Submissions in response to SSD-10421 WEIGALL SPORTS COMPLEX, SYDNEY GRAMMAR SCHOOL

NAME – Margaret Shearer

DATE – 16 December 2020

1 EAST ELEVATION

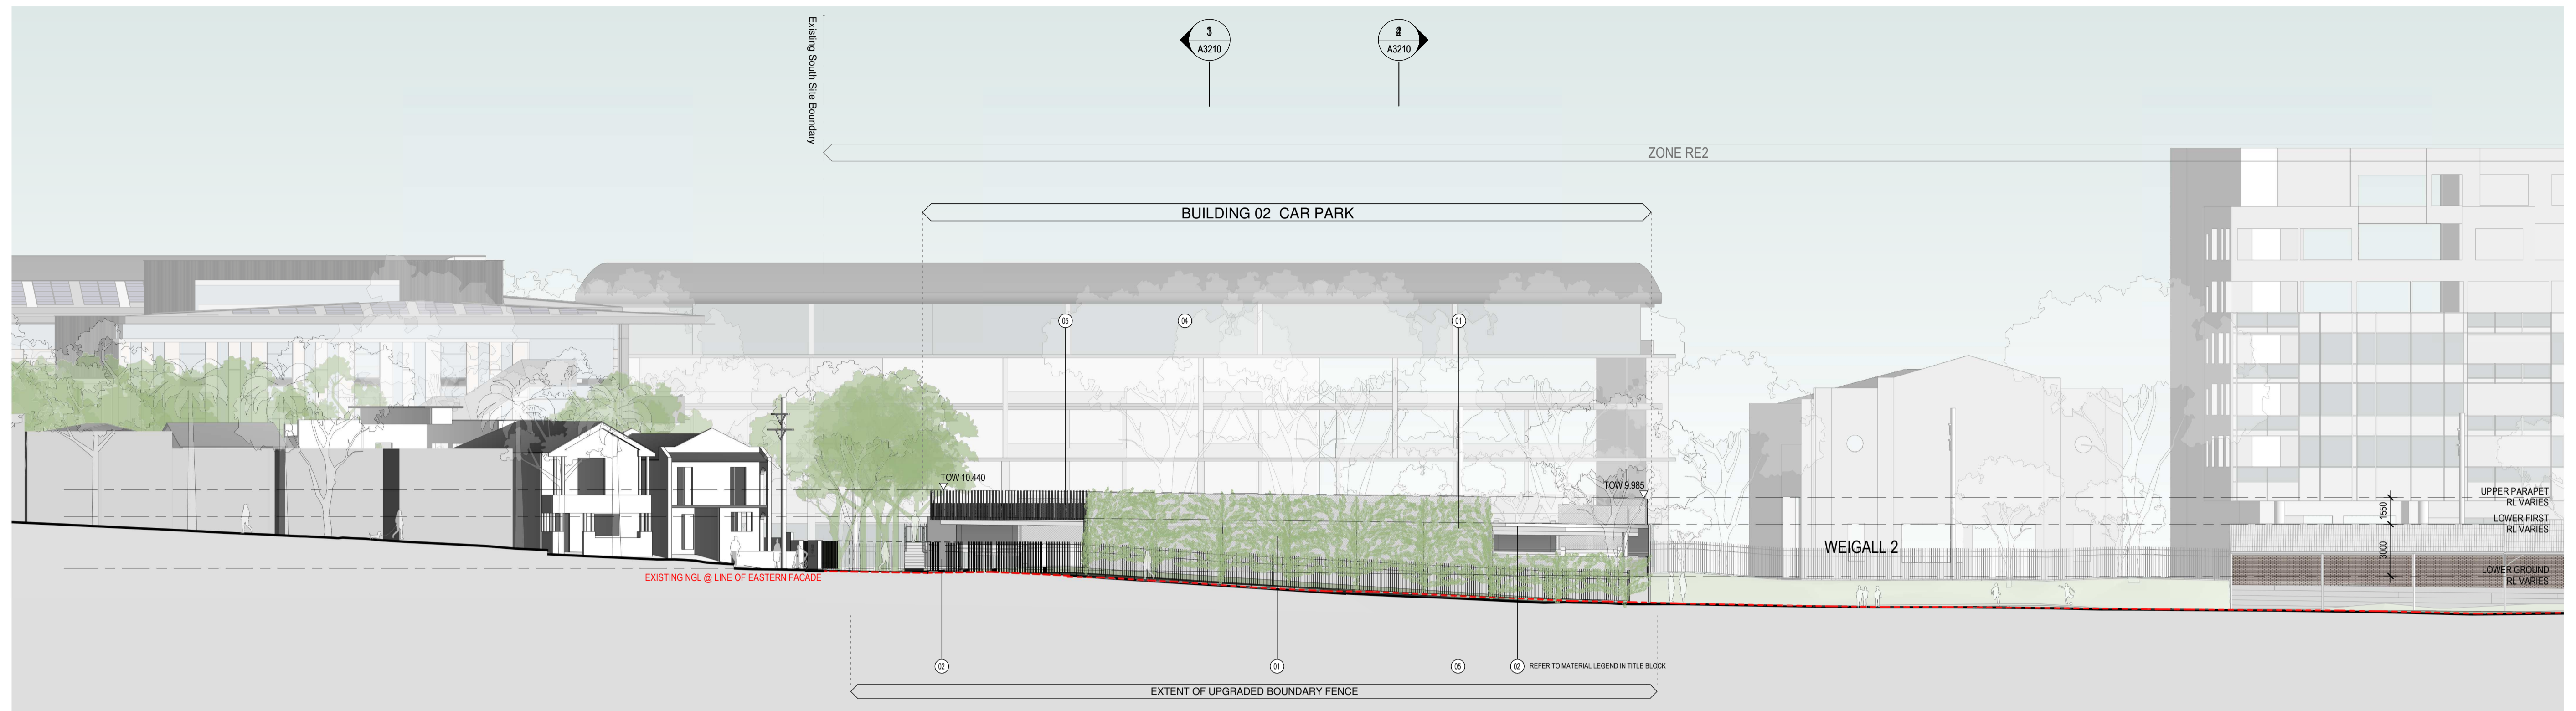
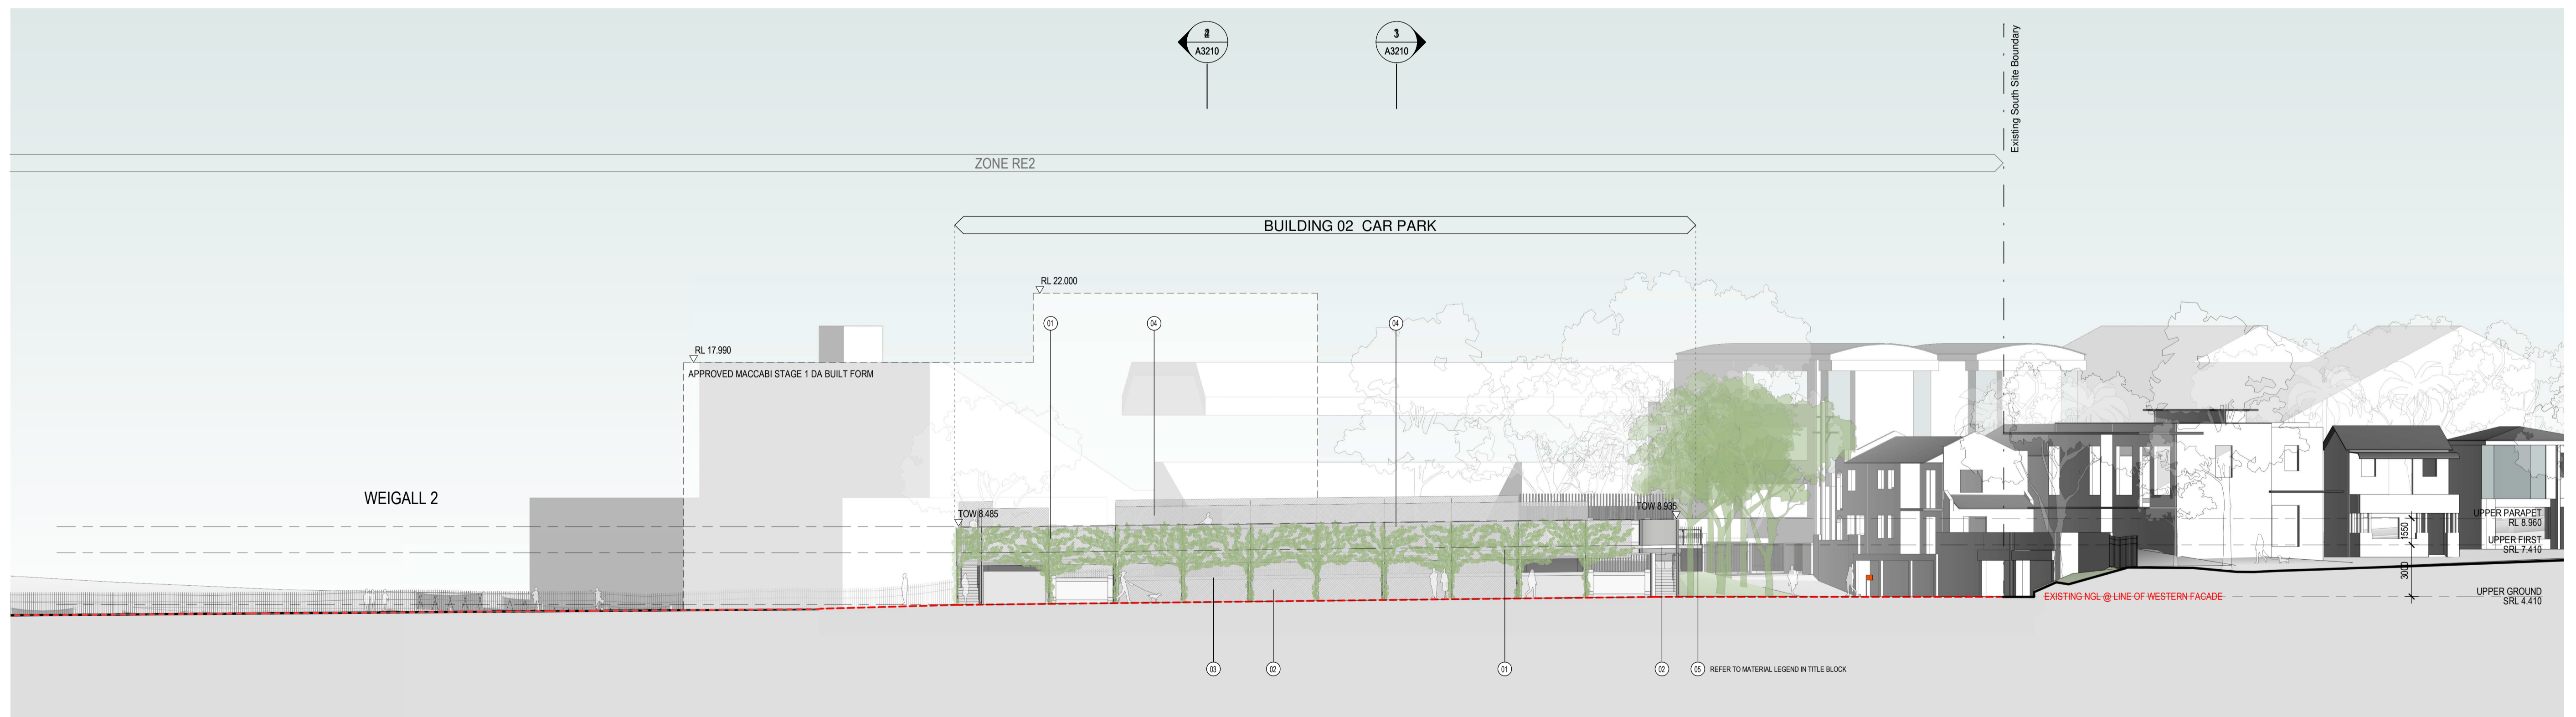
Exacerbating this impact is the fact that along Neild Ave, the western facing building form façade of the Development is a solid wall mass (despite some variations of finish) and there is insufficient specification for the planting of trees to replace the significant tree loss from removal of Critical Trees. In fact, unlike residents to the south and east of the Development, the Affected Neild Ave Properties who were omitted from the assessment, are, under the Development as proposed, left facing the full bulk and height of the Development, which will have a high impact and little to *“mitigate the effects of the bulk and scale of the proposed development”* – (Visual Impact Assessment Report, Photo Montage pp21 and 23)

For Affected Neild Ave Properties anywhere to the north of the Main Building, they will not only face the bulk of the western wall of the Main Building but also the northern face of the Main Building (to a greater or lesser degree depending on angulation). At present, these properties' view of what will be the northern face of the Main Building comprises green space, a small, attractive, old fashioned style, pavilion in muted colours and several mature pepper trees (all slated for removal). As there is currently no planting or landscaping to the north face of the Main Building these Affected Neild Ave Properties will be doubly visually affected (as well as in other ways) as they will be exposed to the both the northern side and western side of the Main Building. As noted, at its longest this visual area will be approximately 81 metres long.

- **that any approval of the Development specify landscaping measures that include planting a mixture of mature, tall (>3metre) trees in order to mitigate the visual impact including:**

- **on the western side of the Main Building;**
 - **further north and south inside the Neild Ave boundary of the Weigall Playing Fields; and**
 - **on the north side of the Main Building, particularly the northern side of the Western Building.**
